KITTITAS COUNTY COMMUNITY DEVELOPMENT SERVICES

RE: Johnson Shoreline Exemption Application (SX-24-00012) – Request for Information

Parcel # 145133

A1	Site Plan
1" = 30'-0"

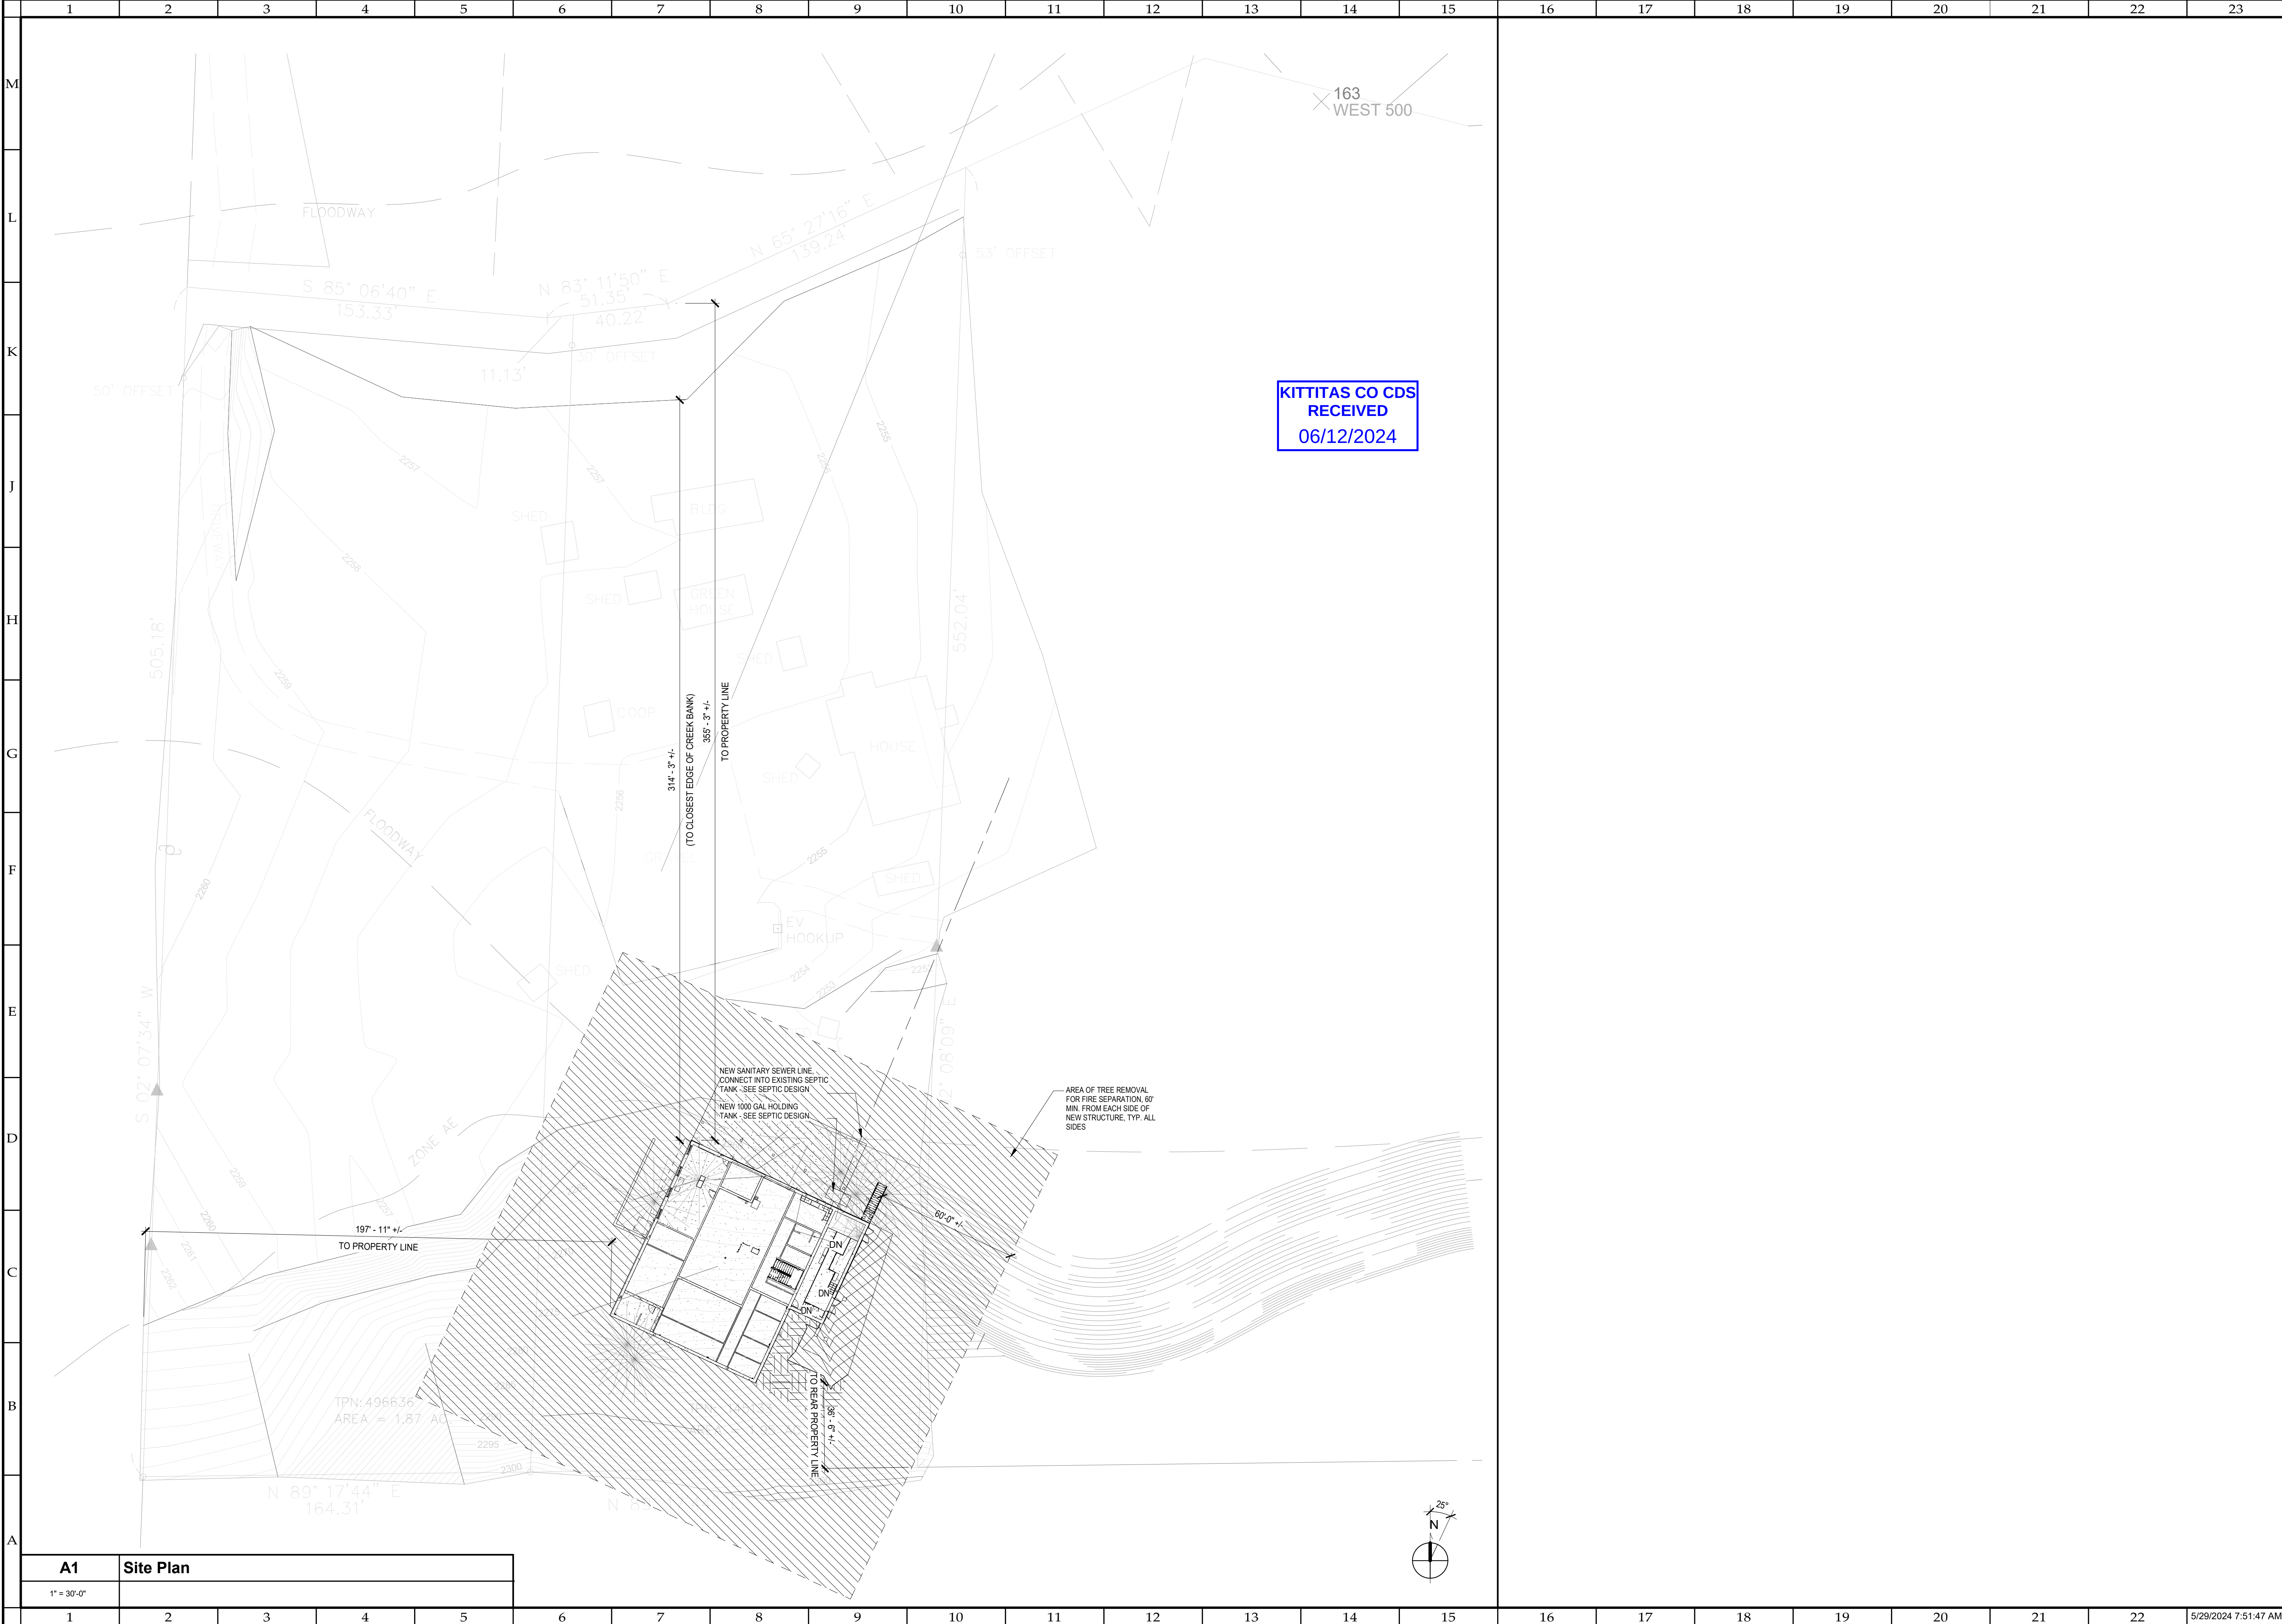
As part of the Shoreline Exemption review process, your project was sent to Kittitas County Public Works for review. Comments were returned with concerns related to the proximity of the proposed structure and the floodway.

A certified survey of the parcel showing the location of the floodway shall be required to ensure the proposed structure does not encroach upon the floodway.
